From: Martyn White
Sent: 28 August 2020 16:52
To: Planning.Responses
Subject: AL/49/20/PL

Byfields & Nightingale Cottage Nyton Road Westergate PO20 3US

Demolition of 2 No existing dwellings & erection of 7 No. dwellings with associated parking, bin store, alterations to the existing access & extension of the existing footway.

Dwellings 1 & 2

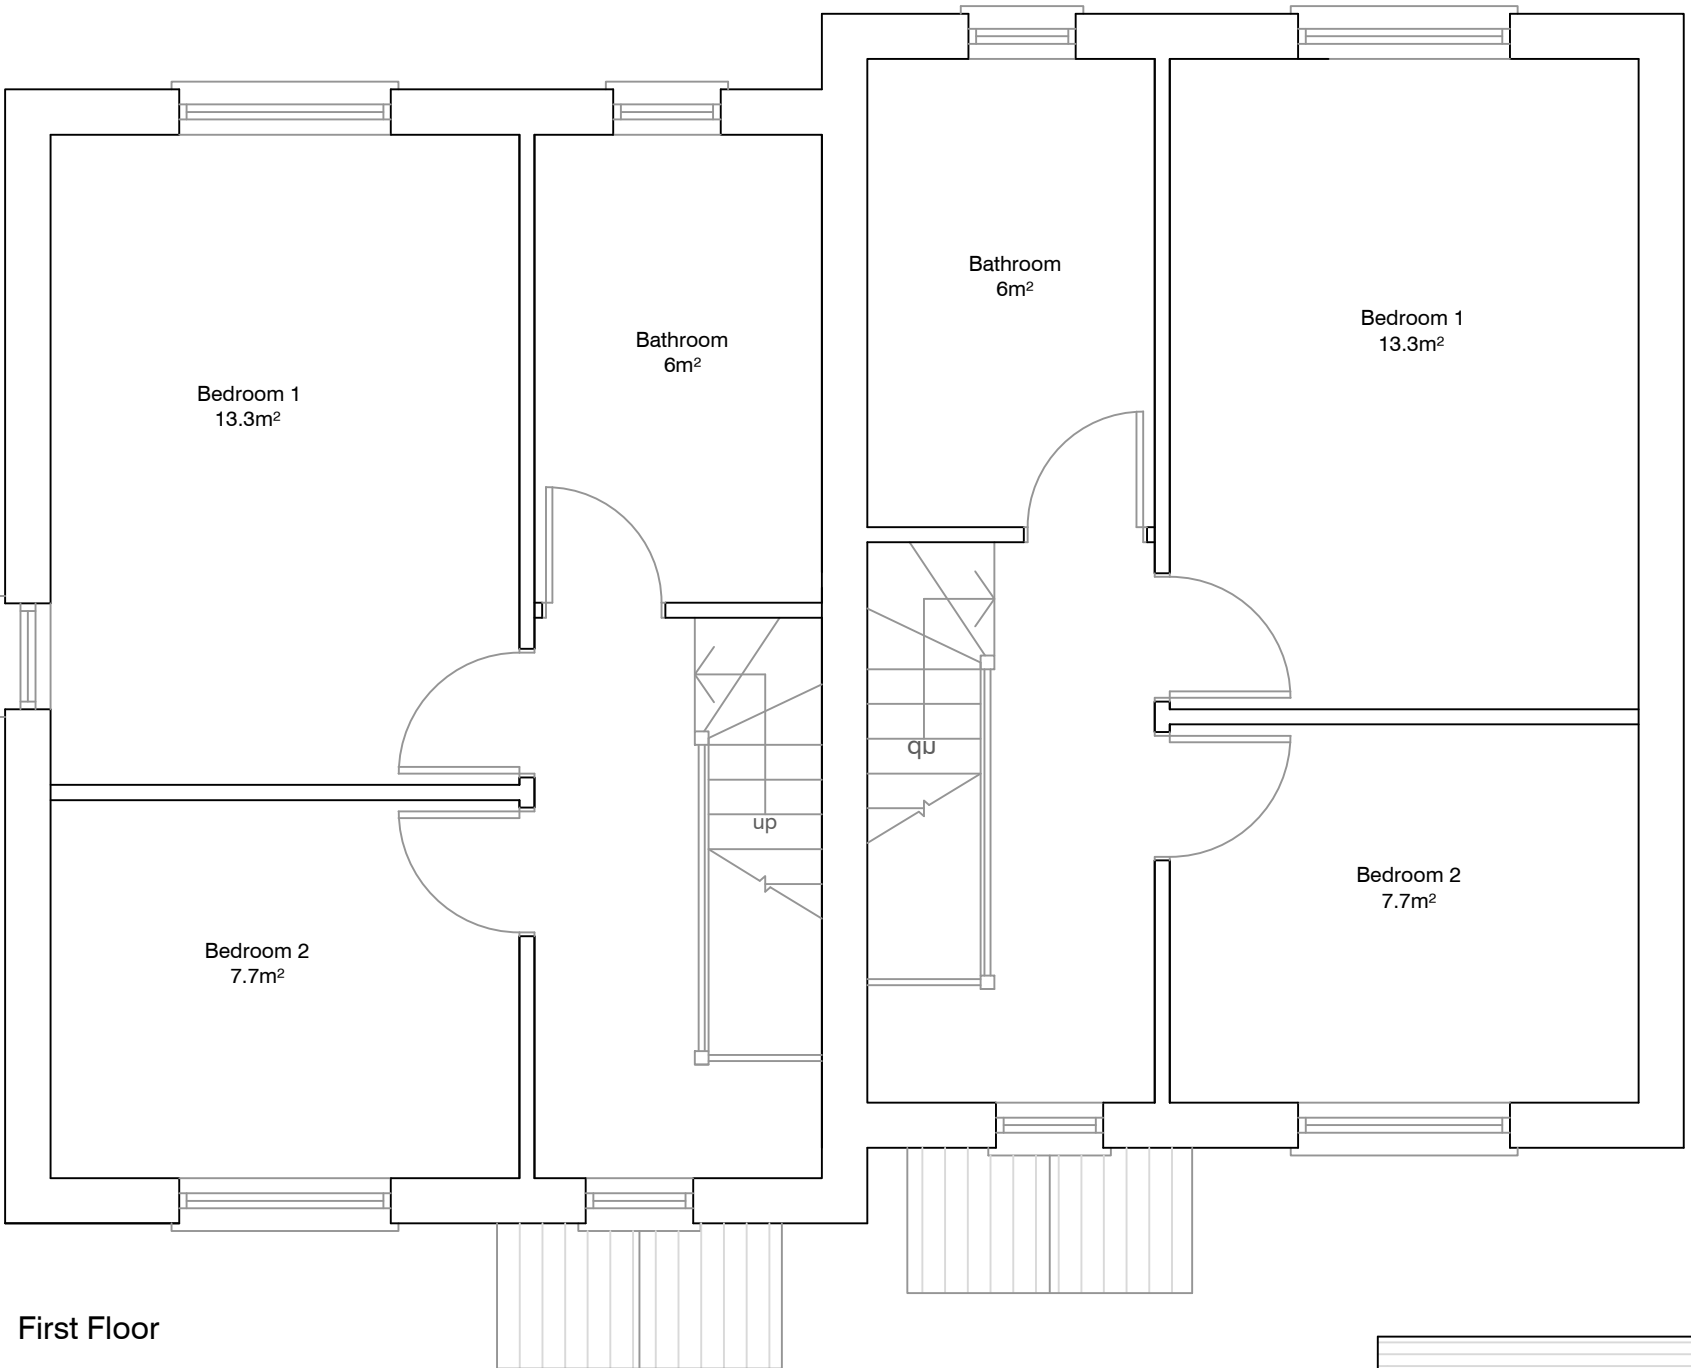
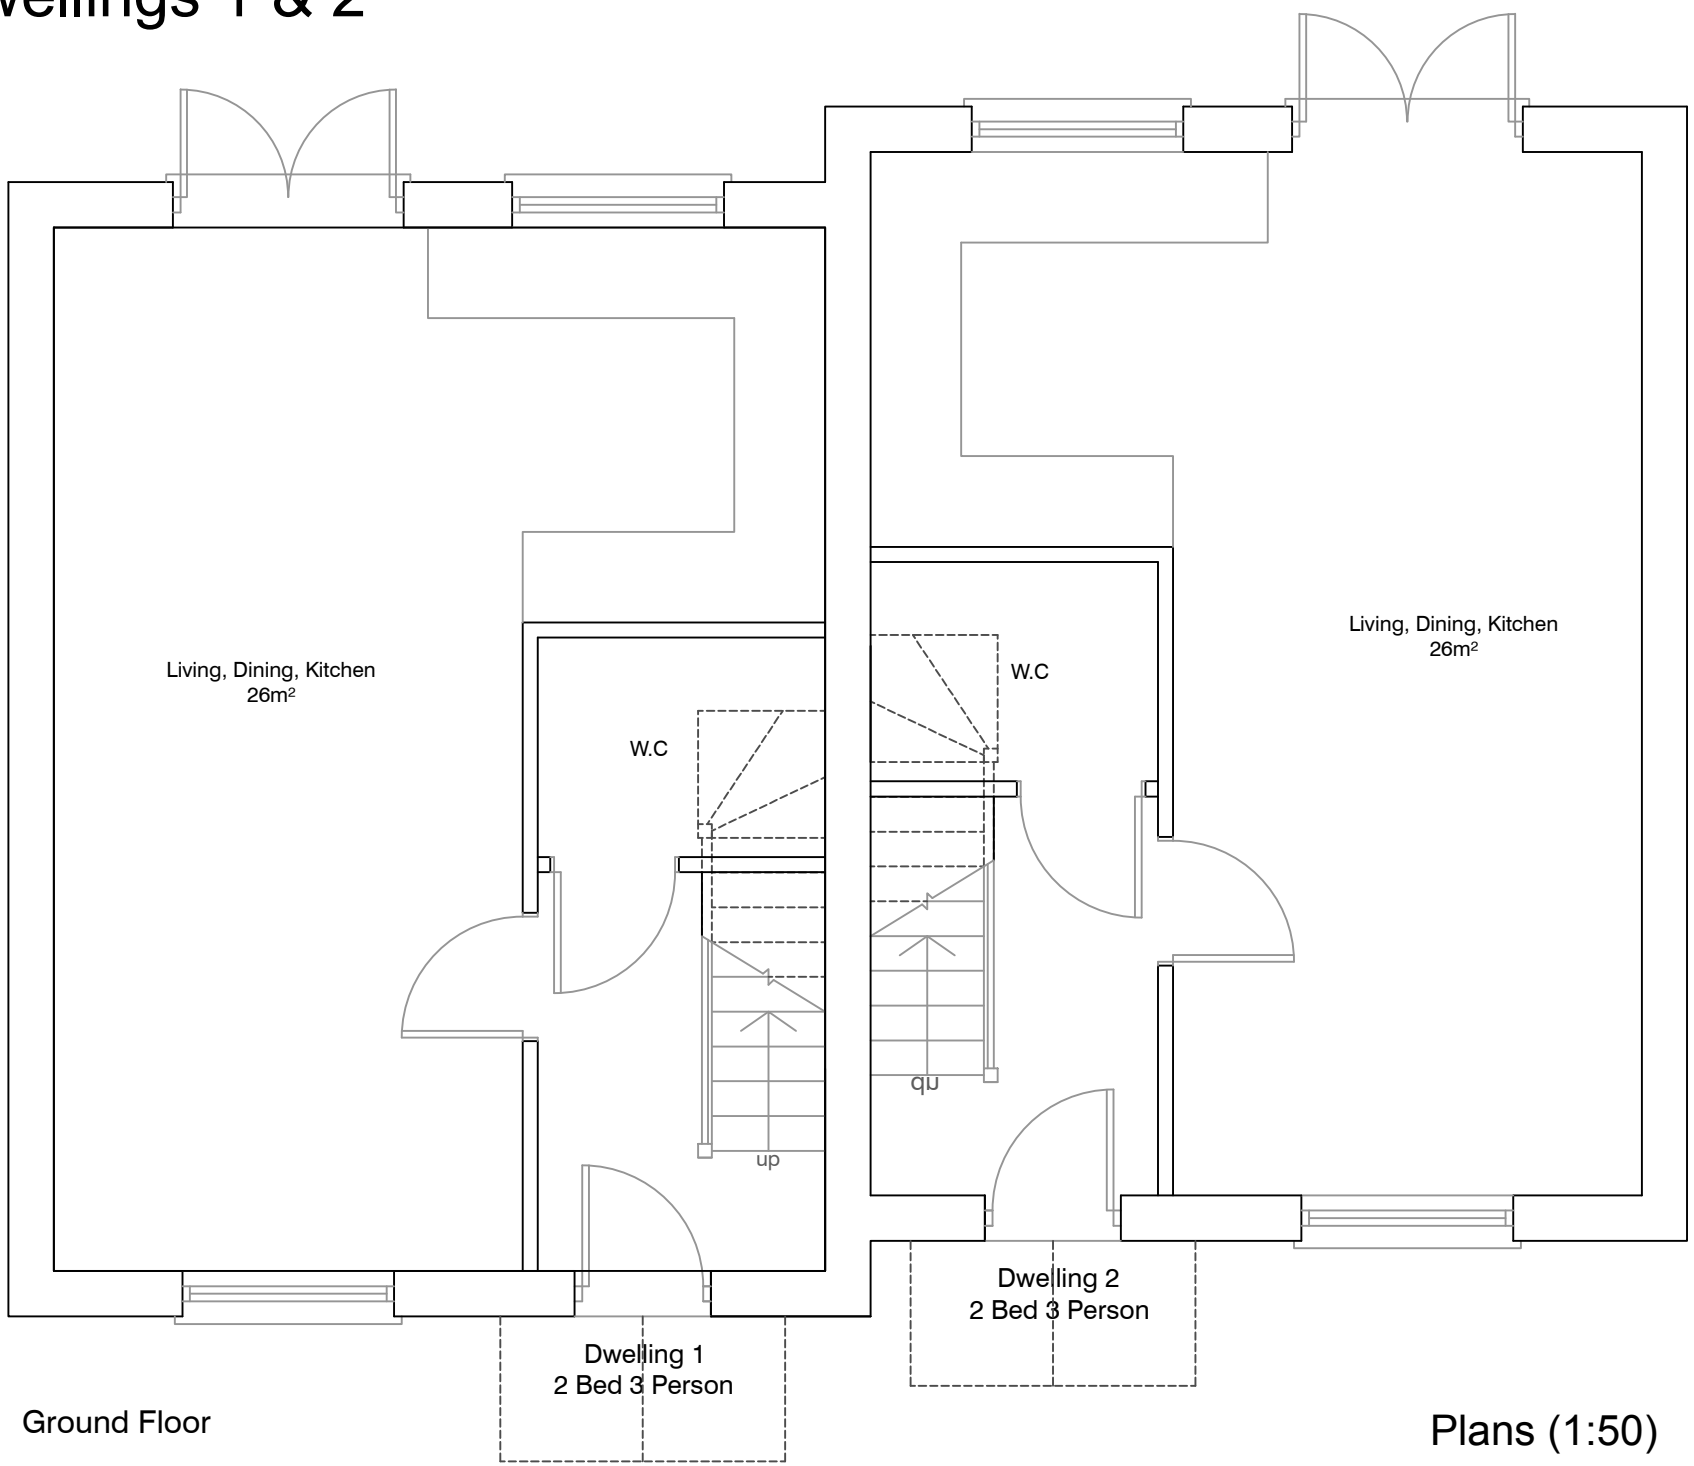
The proposed houses on the Byfield element of the development would appear to be informed by other properties in the locality. Such an idea is a positive one as it would enable it to sit more comfortably in the local area. However, at present, I am of the opinion that some of the details are missing, which will mean that there is the potential for them to appear more as a standard design. I am thinking of the porch detail, window detailing, materials on the front elevation and chimneys which are all seen on the photographs of the two local properties provided as part of the application. All of these small details help to form a more pleasant building, and to fit in with the surroundings.

Whilst there are some positive features of the proposals such as the attempt to replicate other properties in the area, the development is still not capable of support from a heritage perspective due to the lack of detail and the loss of the existing and attractive cottage and flint walling.
